Recommendation Report for Planning Permission

REF NO: R/63/26/PL

LOCATION: The Windmill Inn and
34 Mill Lane
Rustington
BN16 3JN

PROPOSAL: Demolition of existing Public House and 1 No dwelling and redevelopment for retirement living accommodation (Use Class C2) comprising 28 No retirement living apartments and 3 No retirement living cottages, including communal facilities, access, car parking and landscaping (resubmission following R/143/24/PL). This application is in CIL Zone 4 (Zero Rated) as other development.

**Proposed Site Layout
and Positively Drained Areas Plan**

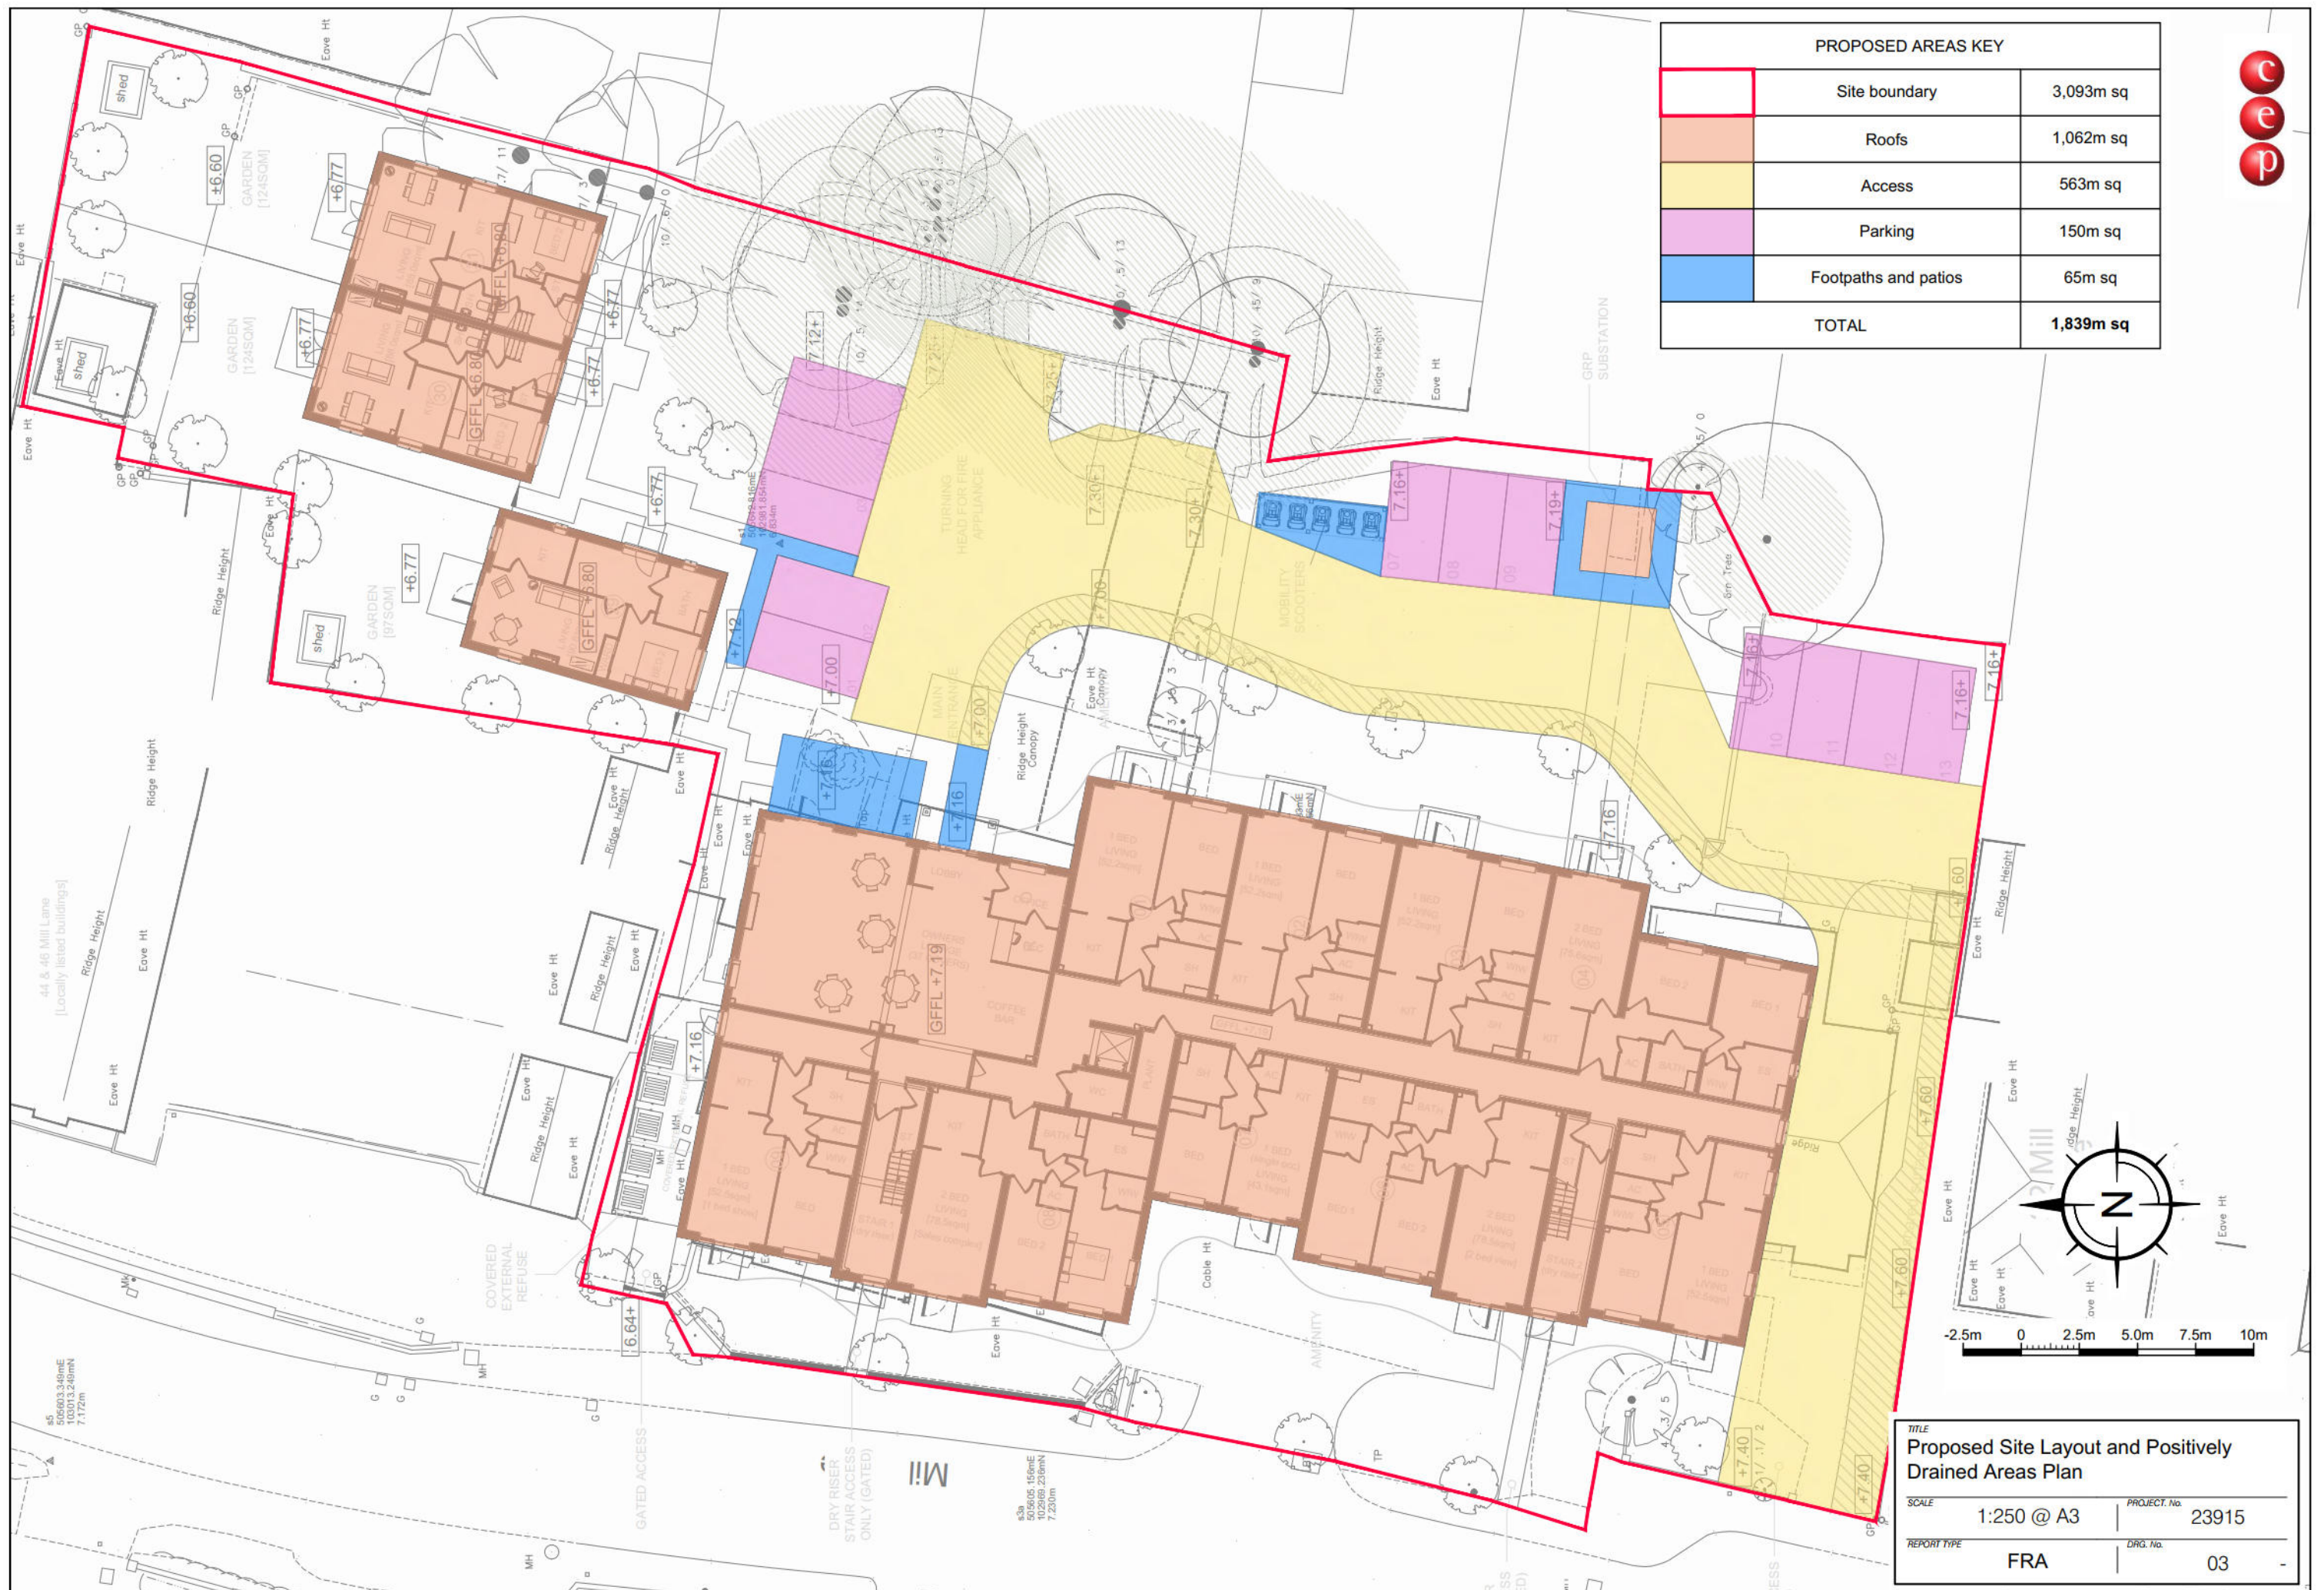
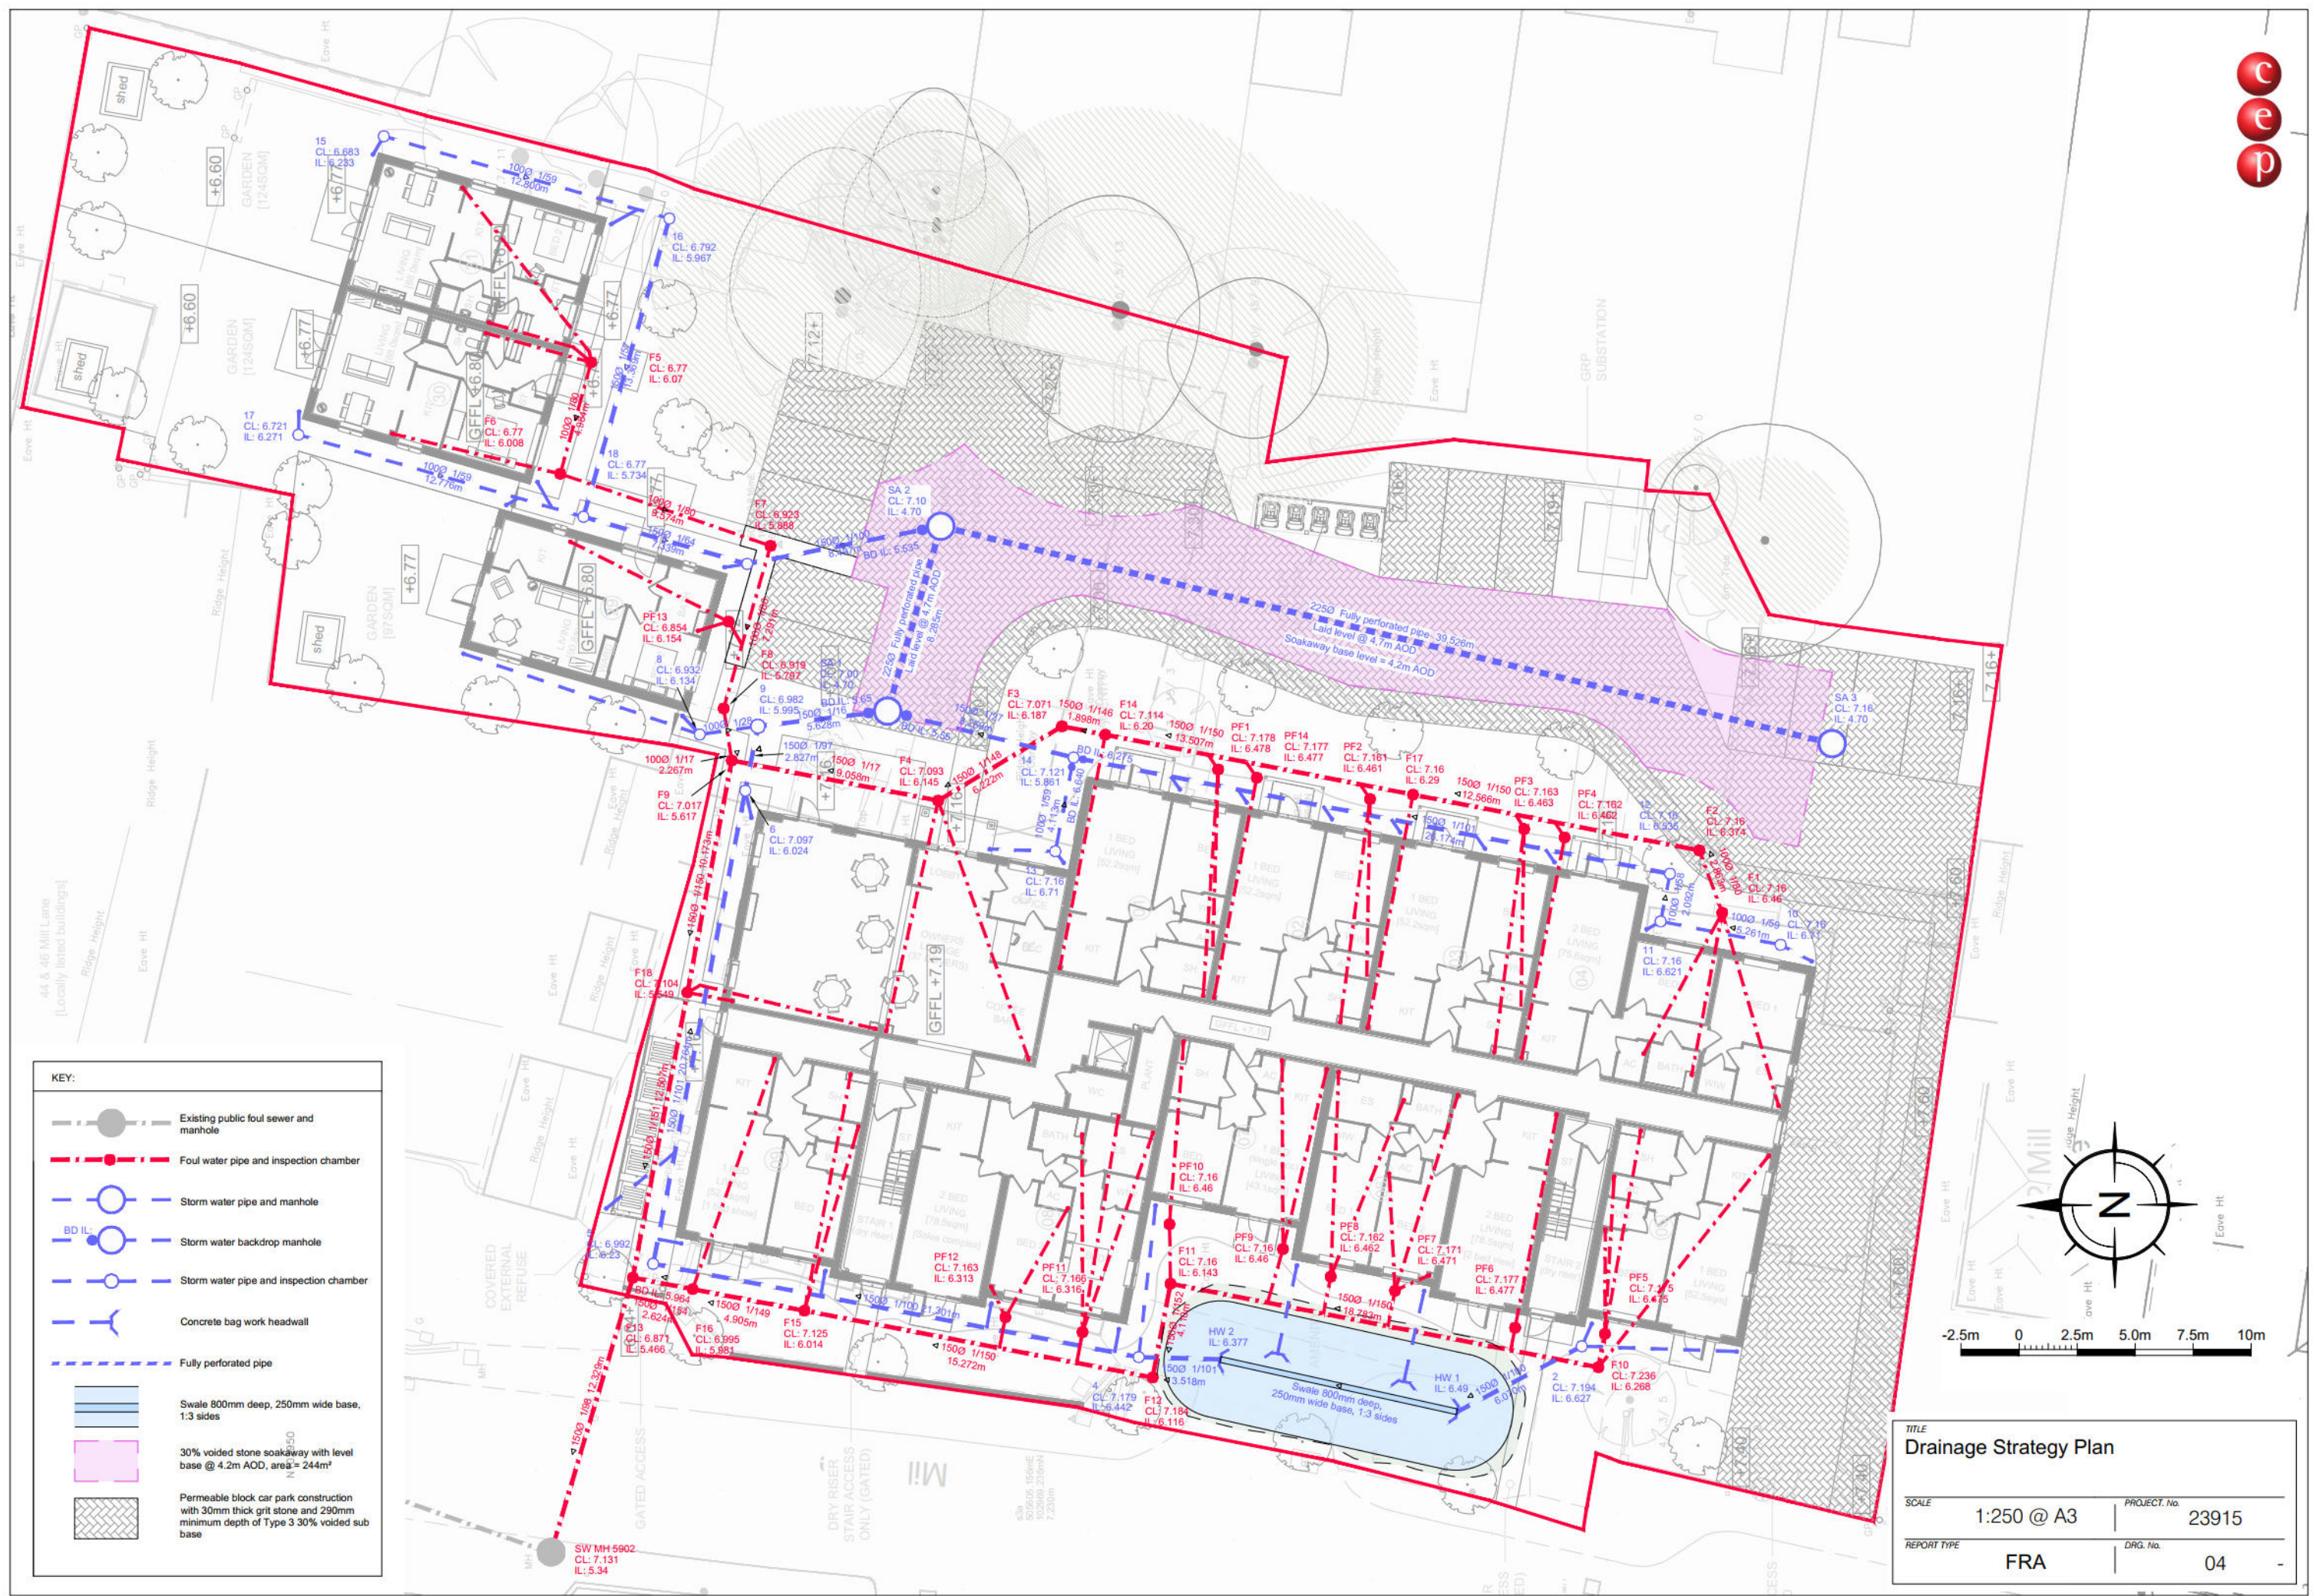
The SuDS would be located under the carpark at the rear of the site as well as a smaller one at the front of the development. There would be no provision for external drainage options from the SuDS to a drain or watercourse. The FRA also provided testing and calculations in the event of extreme rainfall and flooding.

The groundwater monitoring in the FRA demonstrates that the site has low permeability as well as a high water table. The peak ground water level was measured to be only 200mm below the proposed soakaway base, falling significantly short of the 1m separation distance required by the NSfSDS. Without an external drainage option to allow for outflow, officers consider that the SuDS would be unable to fully absorb surface water runoff in the event of extreme rainfall and flooding. The lack of a vertical buffer also risks pollution to groundwater where no filtration through natural subsoil occurs and the drainage system discharges directly to groundwater. This is contrary to sustainable drainage standards as well as Environment Agency policy.

No infiltration testing has been provided for the shallow subsoil layers further from the water table, which have been discounted from the design. It is therefore not certain whether an alternate shallow infiltration solution is possible. No assessment of alternative offsite outlets is presented with the planning application. There may be options yet to be explored to connect to a watercourse, sewer or highway drain which have not been presented.

In their assessment of the Flood Risk Assessment (FRA), the Council's Drainage Engineers reviewed the calculations relating to extreme rainfall and flood risk and concluded that they were of insufficient quality. The calculations failed to provide satisfactory infiltration modelling, exceedance flow routes, details of flow control devices, or appropriate design buffers.
